**SUBMISSION TO MANGOOLA MINE EA
ON BEHALF OF PROPERTY OWNERS OF
RIVERSLEA, WYBONG PARK, WYBONG ESTATE,
DOLWENDEE AND HOLLYDENE ESTATE**

Report No: 131062_Rep_Final
June 2013
(Released: 28 June 2013)

This section presents the findings of the objective review undertaken of the *Mangoola Coal Project – Modification 6 Noise and Vibration Assessment* released on 22nd May 2013.

NEW SINGLE RESIDENTIAL DWELLING
RD, HOLLYDEEN NSW 2328
LOT 1 DP 1160936

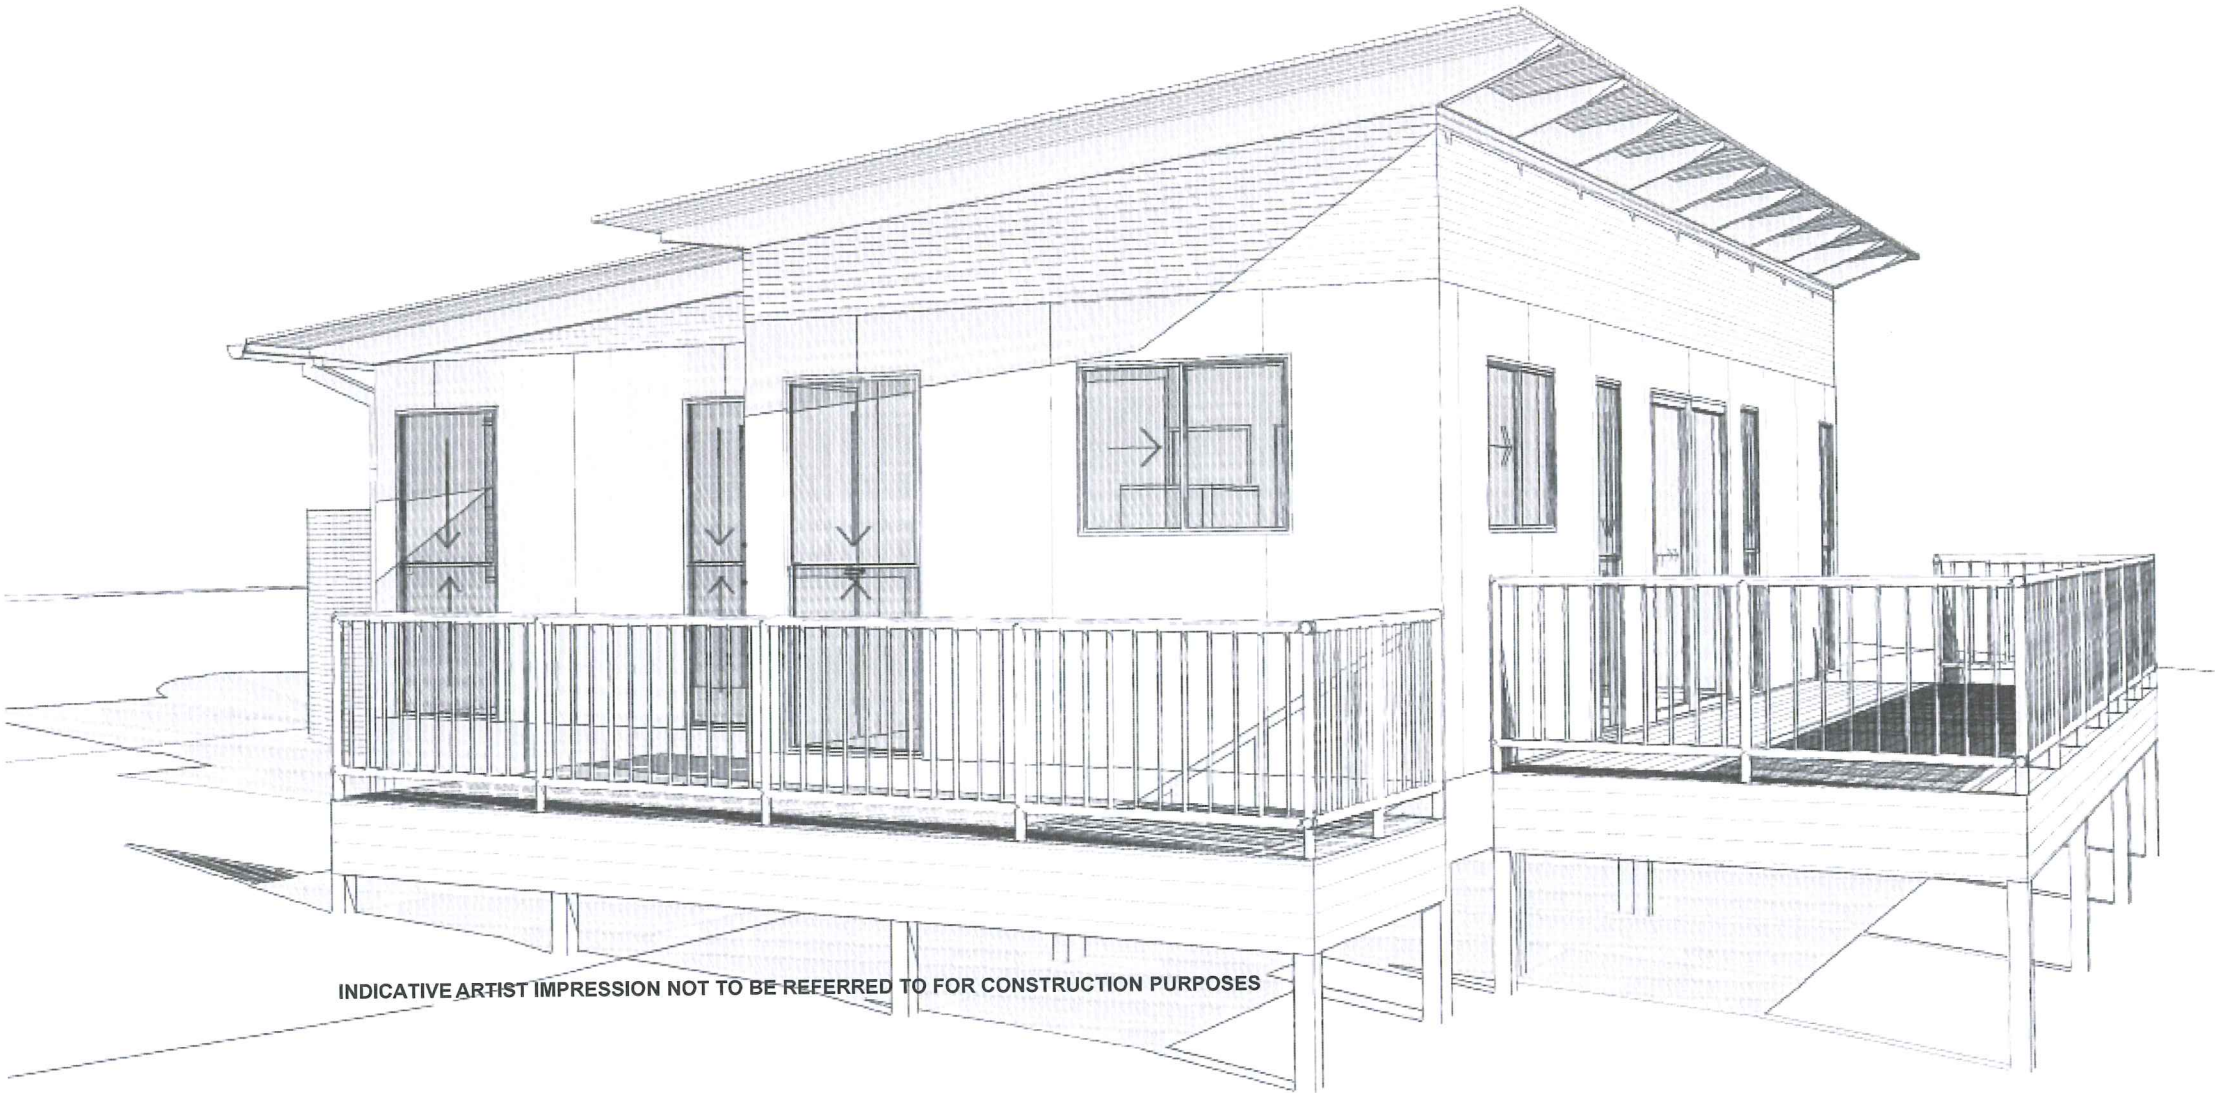
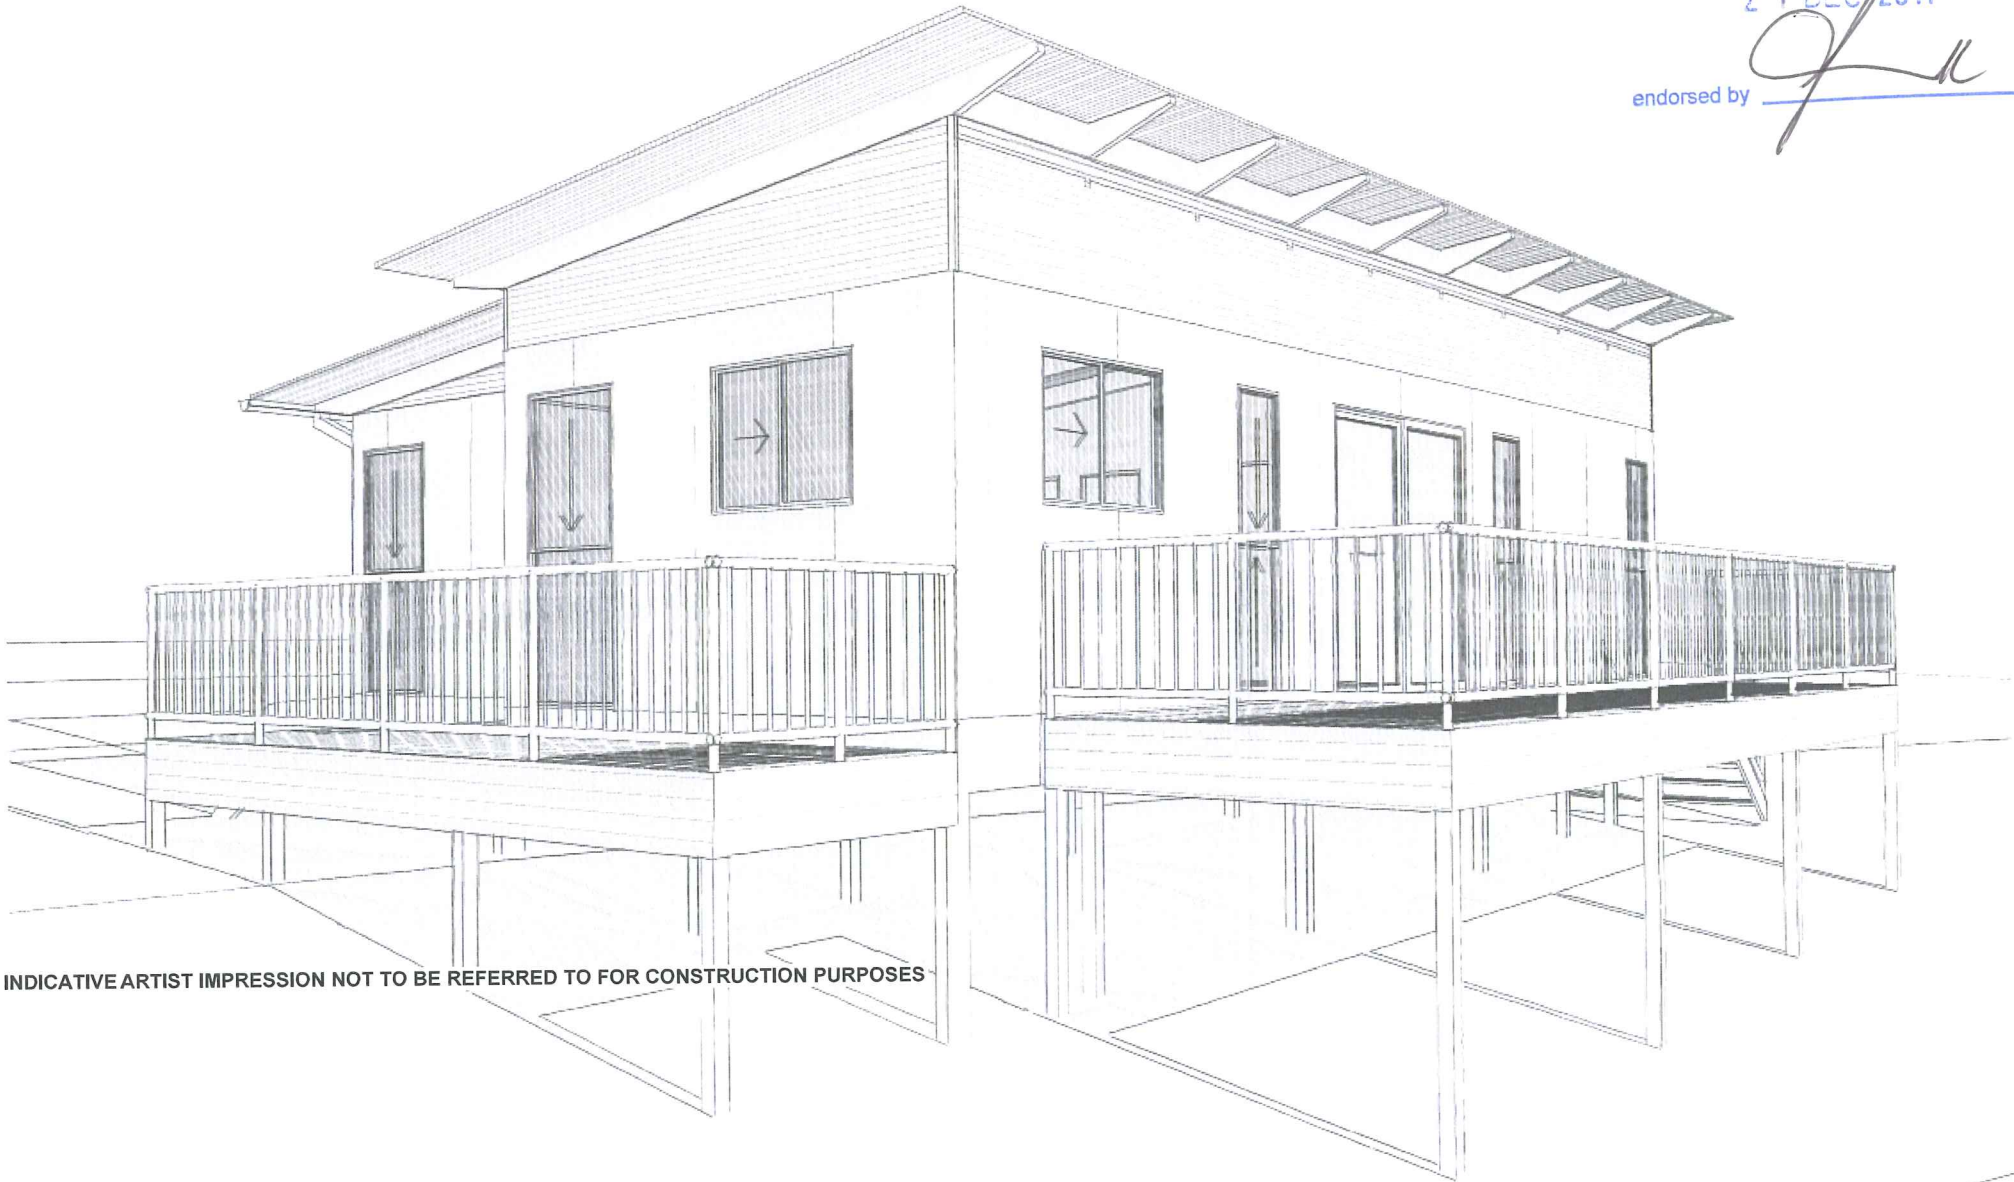
Some receptors have not been included in the study. For example the two land subdivisions present to the south west of the site identified as Lot 1 and lot 2 DP 1160936 have not been considered in this assessment. Note that a development application for two residential dwellings on the aforementioned lots has been approved in 2011.
